Comments for Planning Application 2021/1922

Application Number: 2021/1922

Address: Thatchers High Road Bressingham IP22 2AT

Proposal: Change of use and conversion of existing garage to create laundry & ironing room

Project Title: Thatchers, High Road, Bressingham, Diss, Norfolk, IP22 2AT  
 For: Mrs Karen Wimshurst  
 Drawing Title: Proposed Laundry / Ironing Room

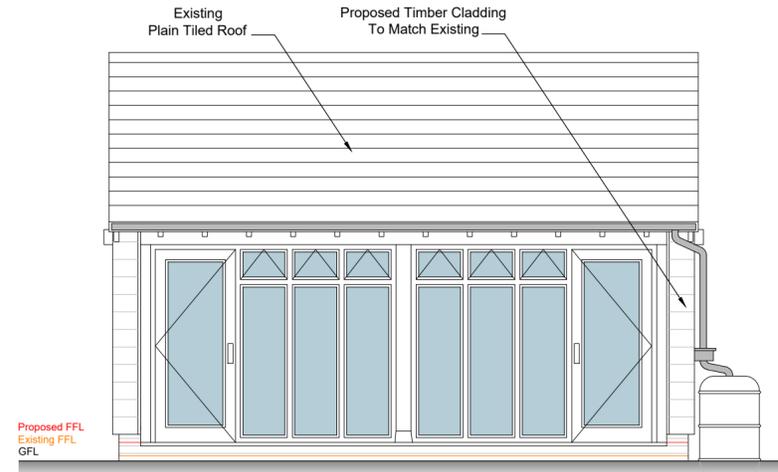
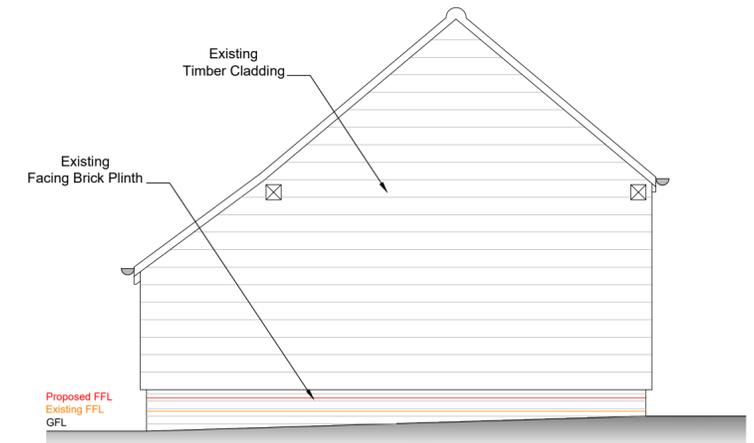
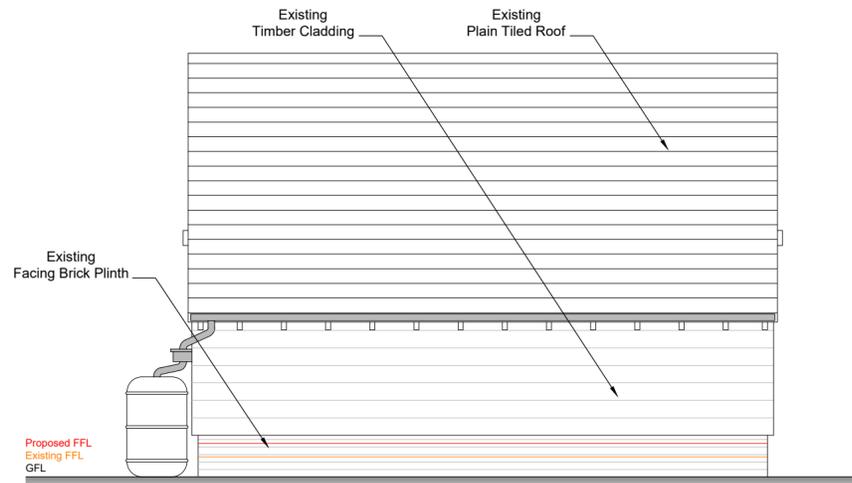
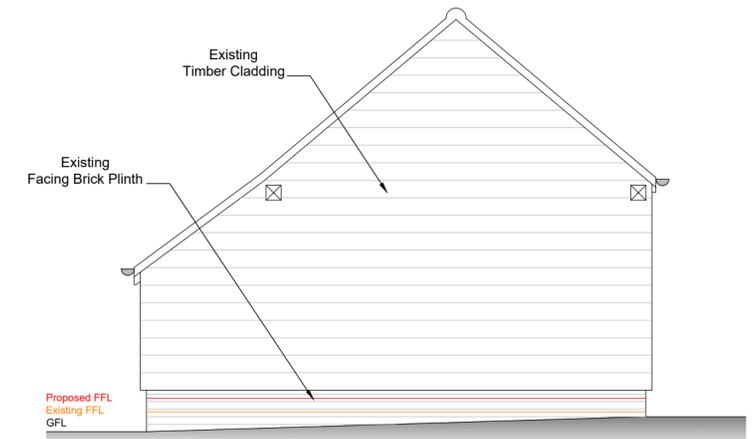
5. In addition to concerns about the local impact and change of use to a laundry business, the design of the proposed conversion and building of new washing/drying cabin is surprising for a listed building as it does not look to be of the quality and appearance appropriate to the setting. The removal of the existing oak curved braces and the installation of a wall of "fixed glazing panels and personnel doors" (no mention of the material - glass/plexiglass/timber/plastic?) will result in an unusual appearance. The washing/drying room (four commercial washing machines and three commercial driers will be running) is a "cabin". This also does not look to be of sufficient quality or suitability for the setting.
